PROW comments on updated MU1 plans 2021/1090 and 1089 send to MU1@barnsley.gov.uk

Full planning permission for: earthworks to create development platforms; strategic drainage ponds/dry detention basins and associated drainage infrastructure; construction of a new link road; location of strategic landscaping and ecological areas; demolition of existing buildings; works to Hermit Lane; and erection of Phase 1(a) residential development comprising 216 dwellings,

5.5 COMPLIANCE: SECONDARY CONNECTIONS

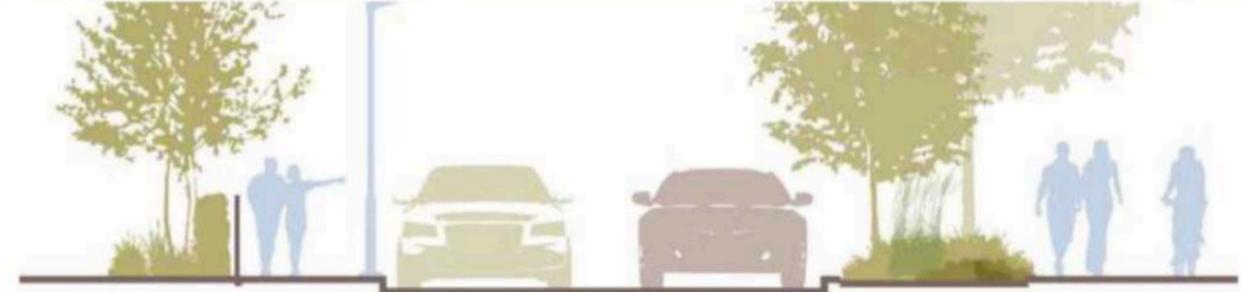
2.10 Opportunities- reference only to upgrading footpaths to cycle paths rather than bridleways

5.12 Health and Wellbeing compliance walking and cycling. There appear to be nothing higher than footpath links into the existing communities that surround the site. Implying that whilst you can walk/ cycle within the development, anyone coming to the new school, shops or other facilities can only come by car or walk.

The discussion needs to be had regarding the upgrading of existing footpaths where appropriate to provide additional cycling options into the adjacent neighbourhoods to get maximum benefit for health and wellbeing, active travel and sustainable transport as well as reducing congestion and pollution
